Application number: 2023/92383	
What is the application for?:	Erection of two storey and single storey rear extension with terrace above and a
Address of the site or building:	11, Moorside Court, Moorside, Cleckheaton, BD19 6AY
Postcode:	BD19 6AY

User comments

SOUTH ELEVATION  
1:100

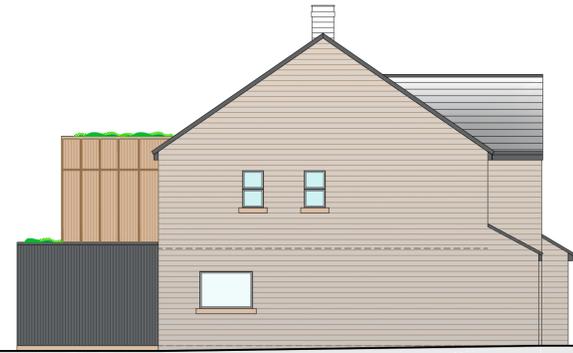
Type of comment: An objection	
Do you wish your comments to be published on the website anonymously?	No
We believe that the proposed plans will be an invasion of our living space and privacy and we also be very instructive. It will also stop the small amount of natural daylight we already have.
